DRB Project Number: 2020-003484 Hearing Date: 12-04-2024
Project: Volcano Cliffs, Lots 2 & 3, Blk 12, Unit 3 Agenda Item No: 3

PR-2020-003484
SD-2024-00158 – EXTENSION OF
PRELIMINARY PLAT

REQUEST: Replat of Lots 2 and 3 - create 19 lots from the existing tracts

PRELIMINARY PLAT FOR
MOJAVE RIDGE SUBDIVISION
 (A REPLAT OF LOTS 2 & 3, BLOCK 12,
 UNIT 3, VOLCANO CLIFFS SUBDIVISION)
 WITHIN
 SECTION 27,
 TOWNSHIP 11 NORTH, RANGE 2 EAST, N.M.P.M.
 CITY OF ALBUQUERQUE
 BERNALILLO COUNTY, NEW MEXICO
 JANUARY, 2023

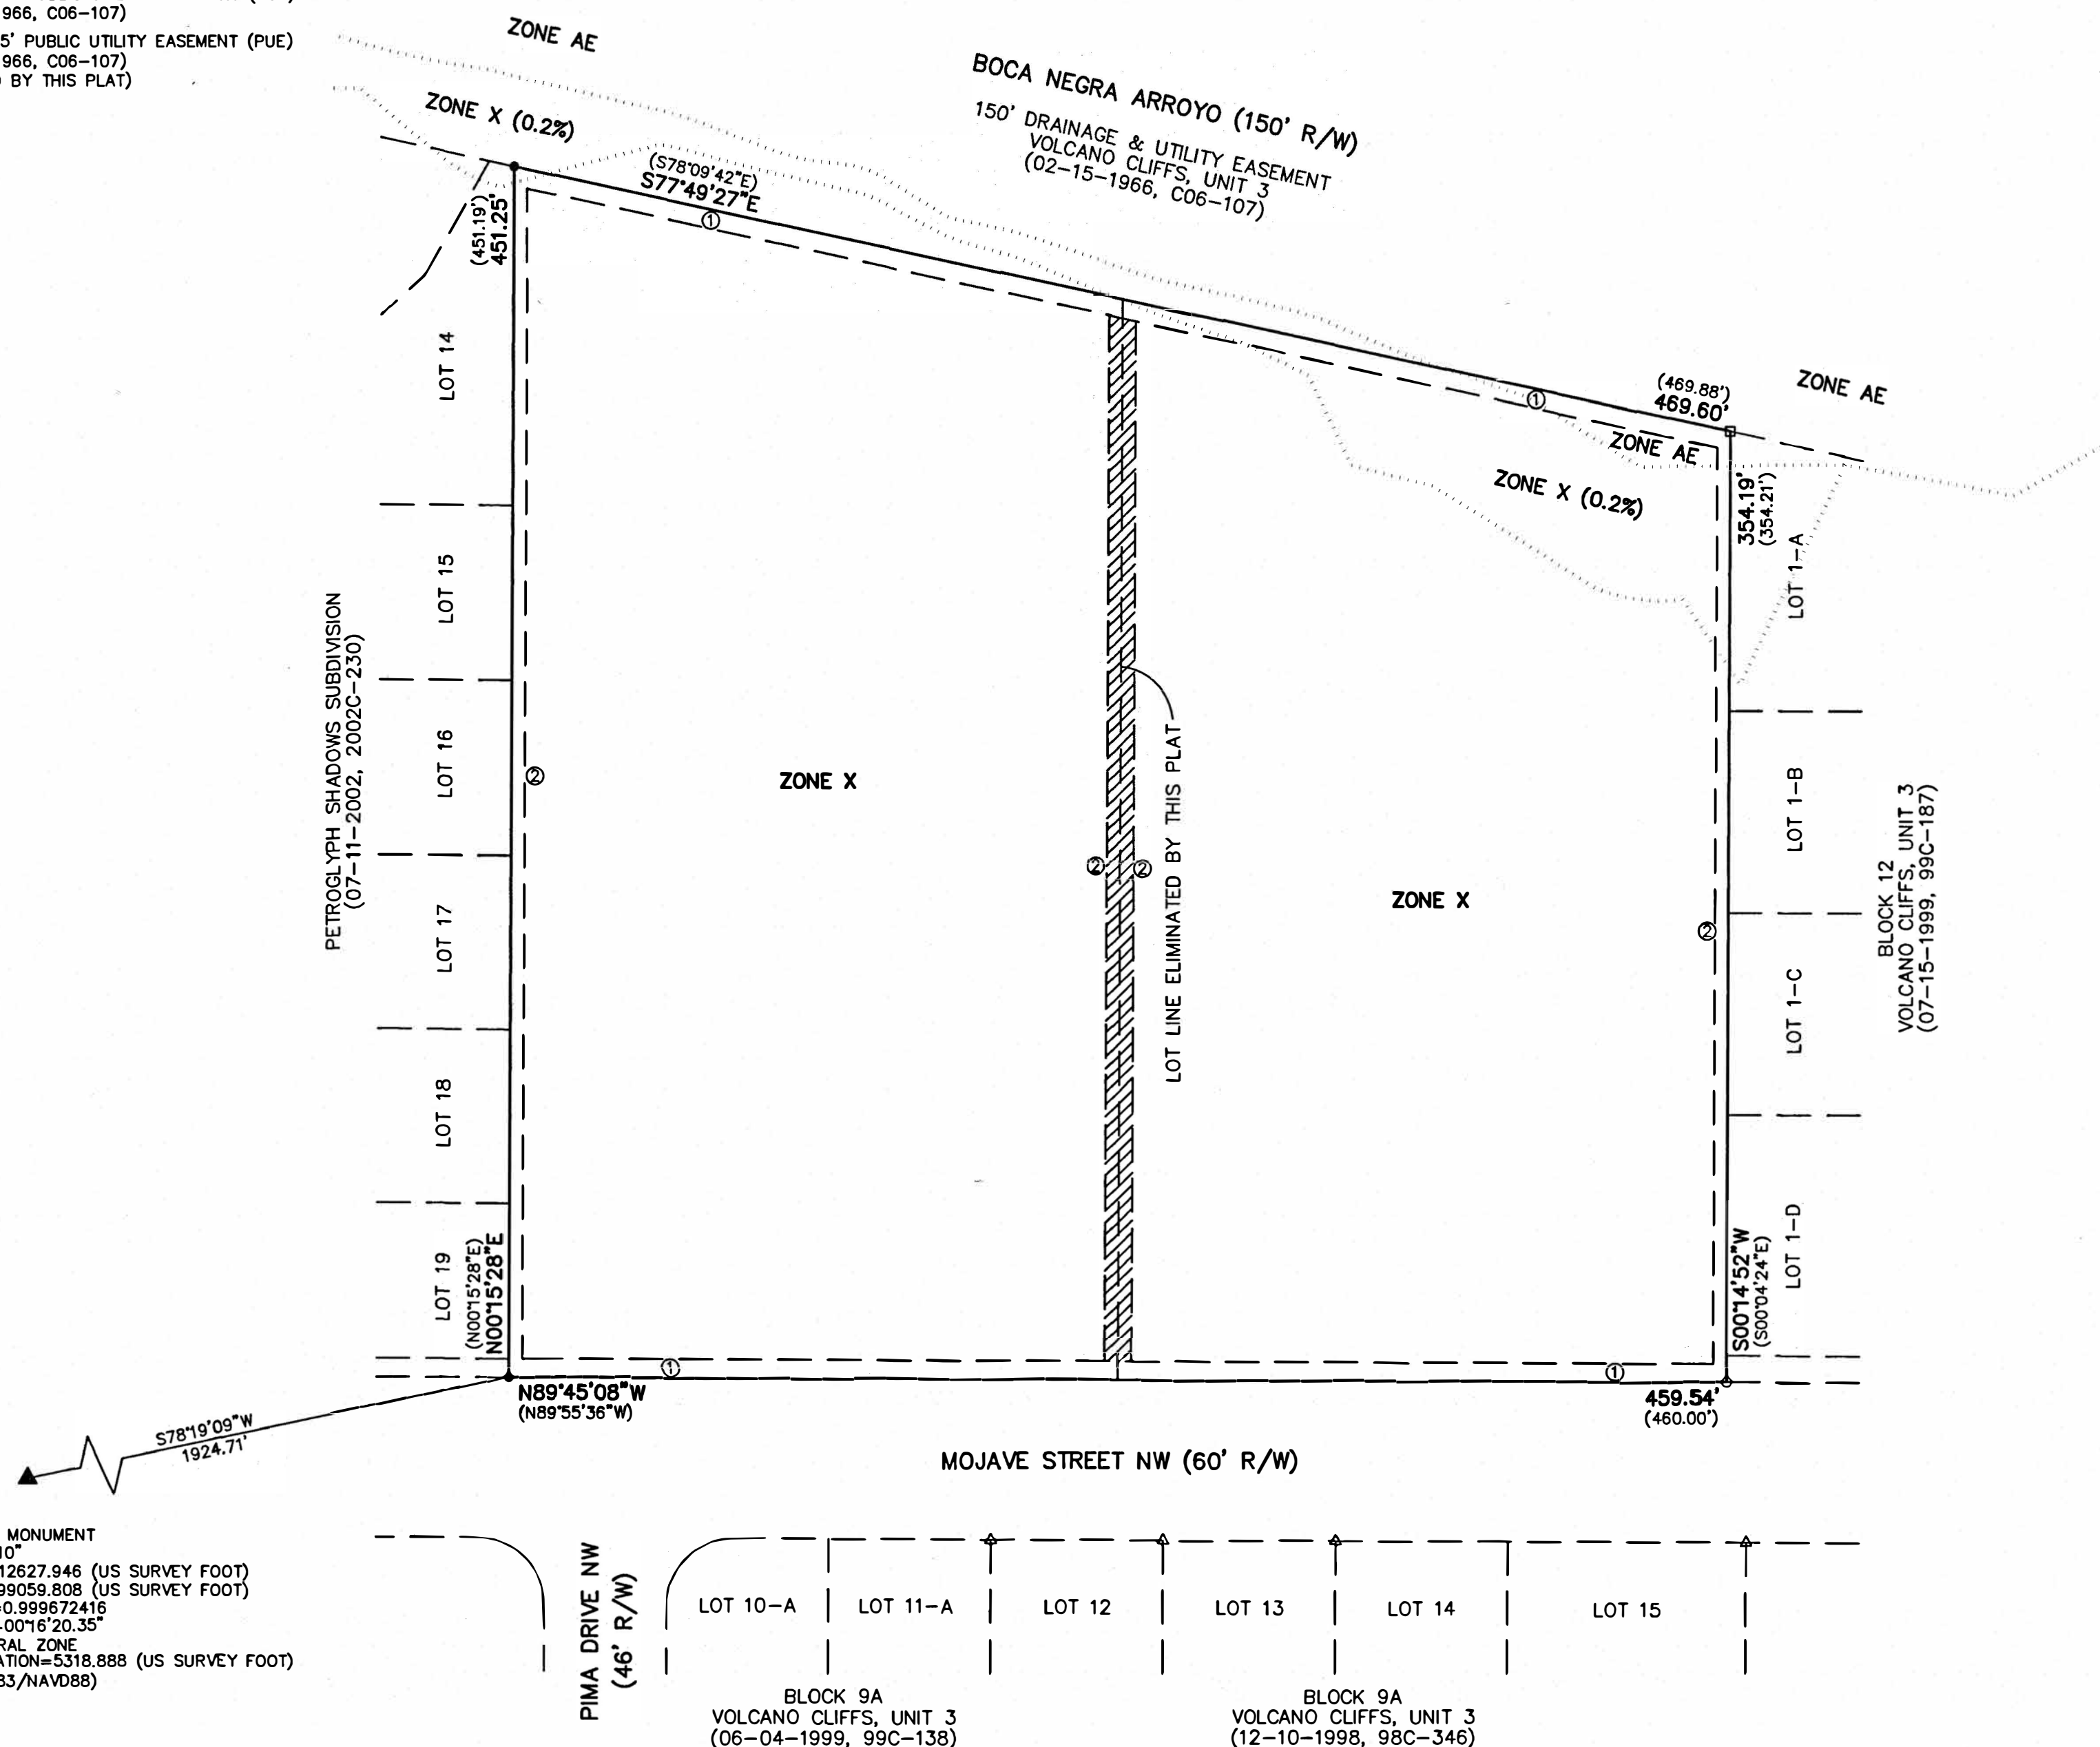
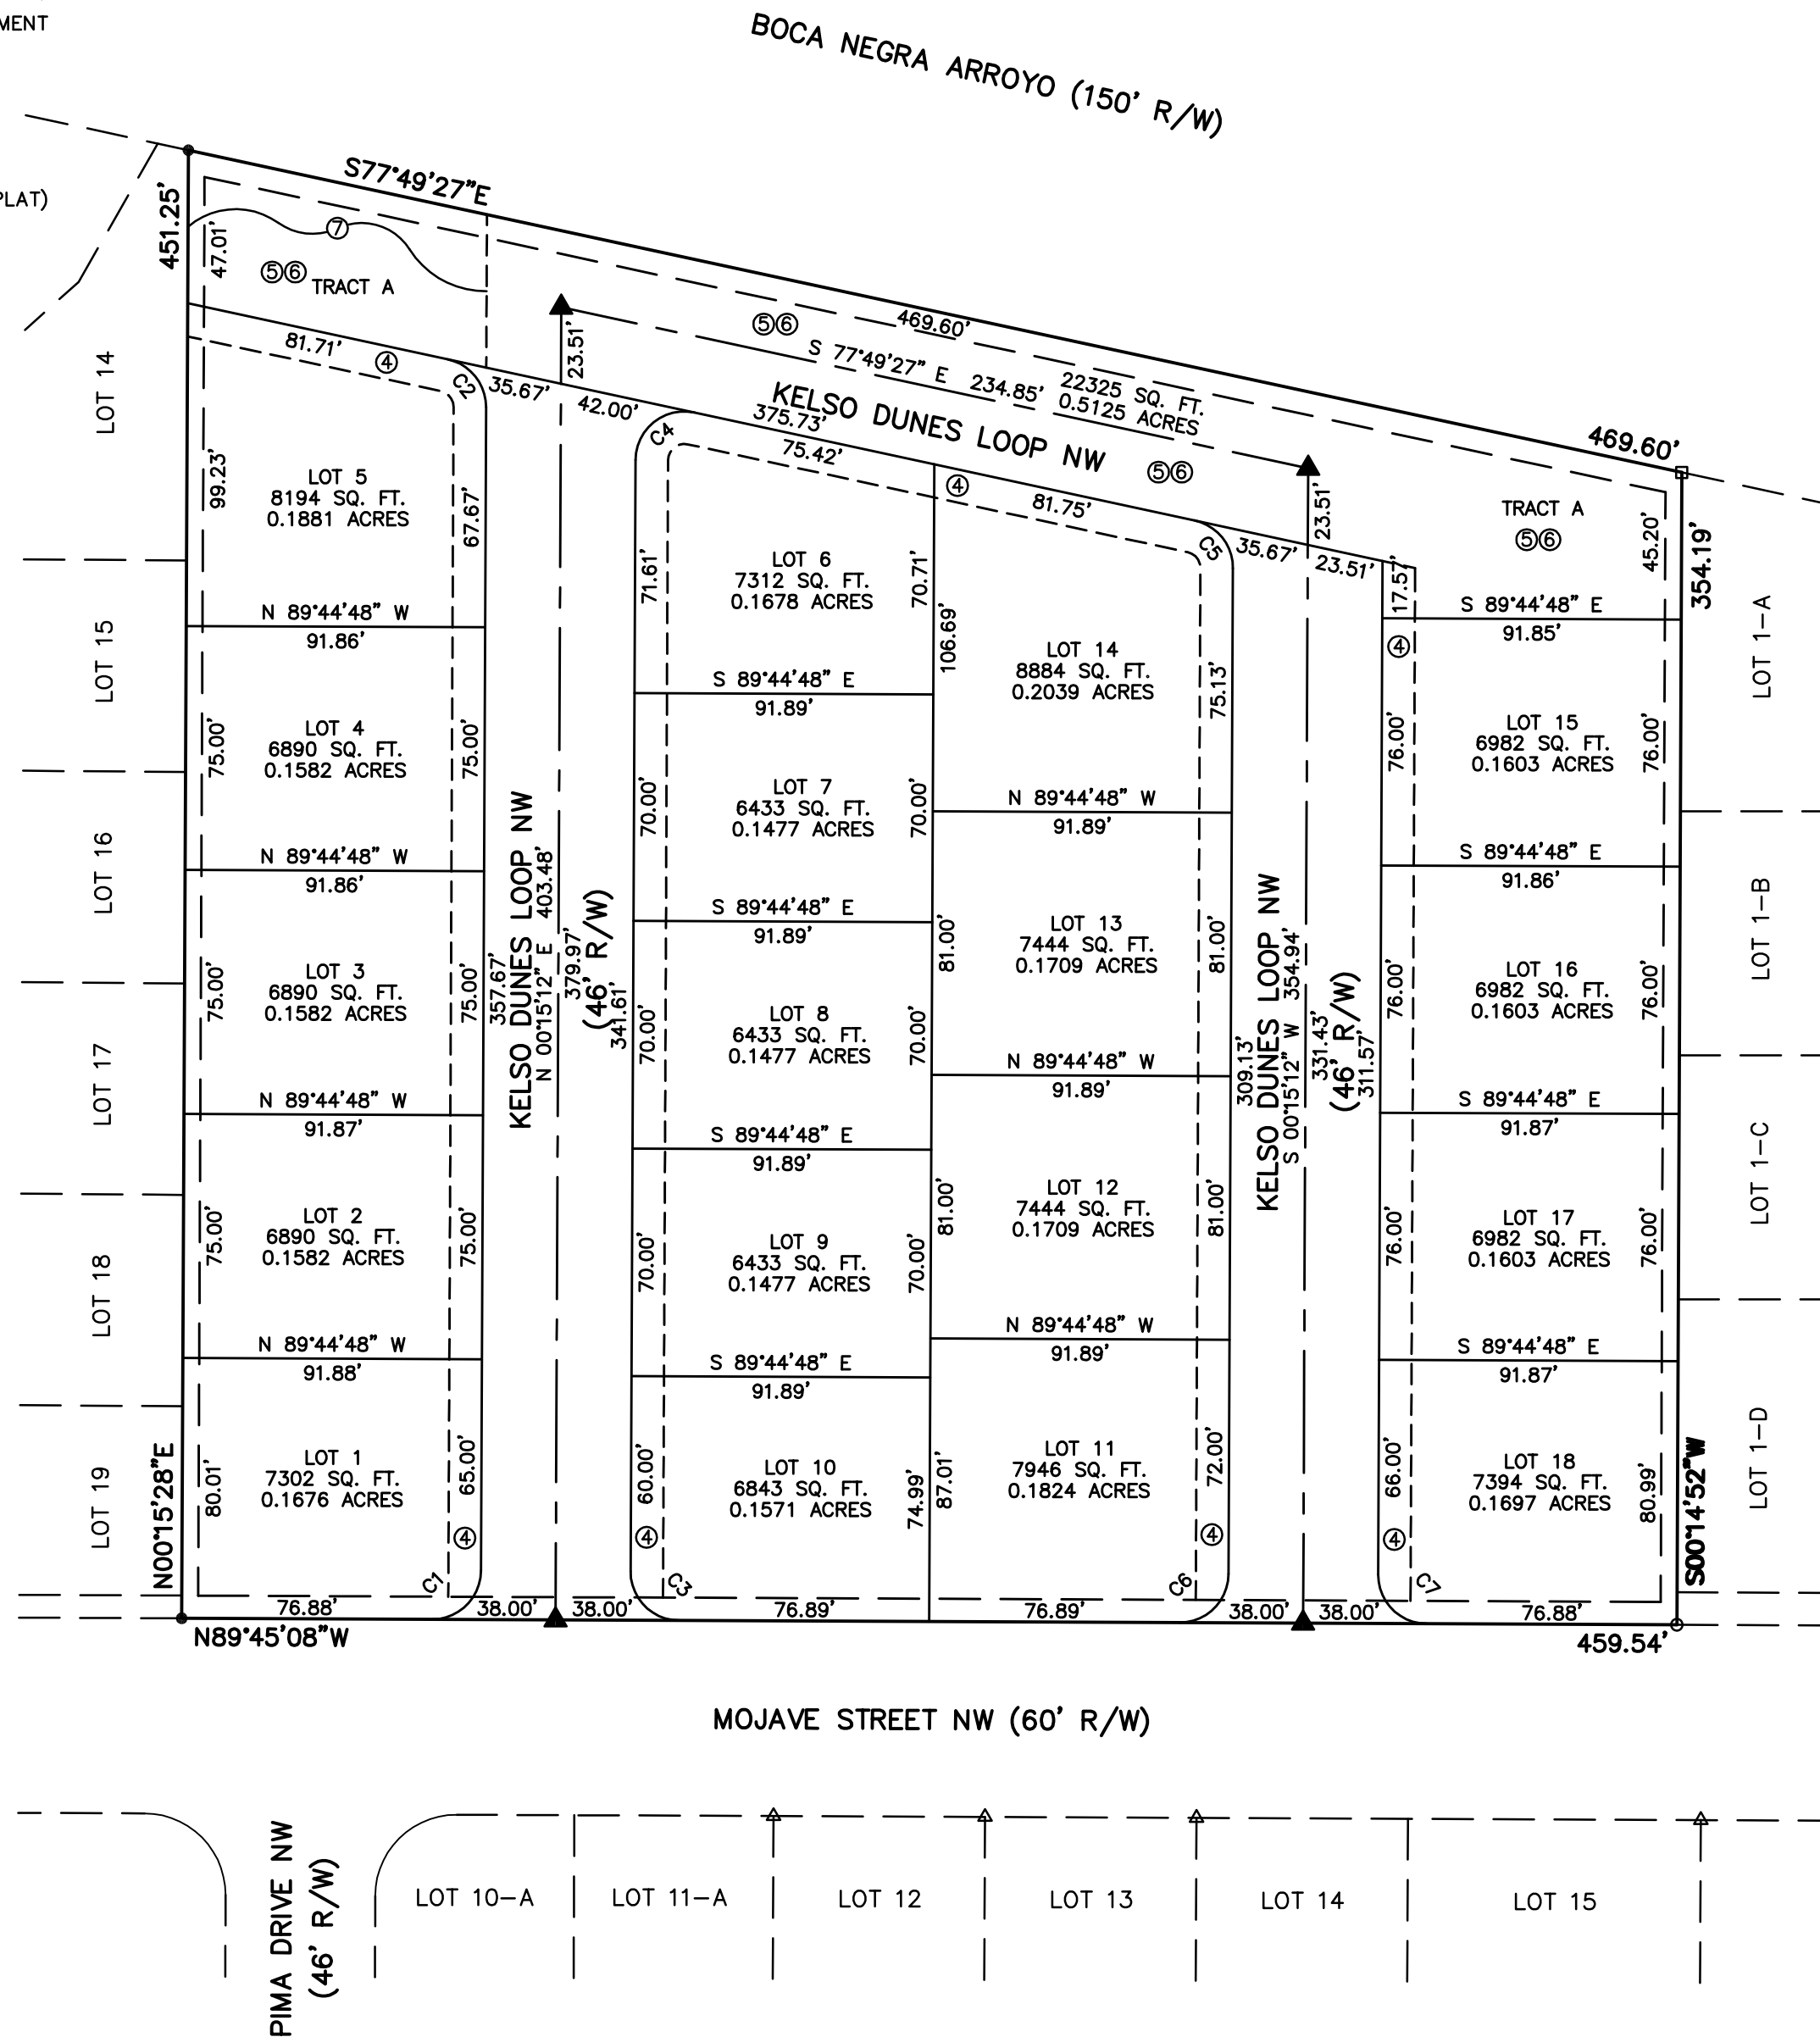
Please note on the plat that the Boca Negra Arroyo parcel is zoned NR-PO-B Major Public Open Space/Petroglyph National Monument. This helps staff identify standards that will be required when the site is developed.

Please note on the plat the **45' landscape buffer** required on Tract A due to adjacency to MPOS – No development is allowed and plant species and location must be approved by the Open Space Superintendent.
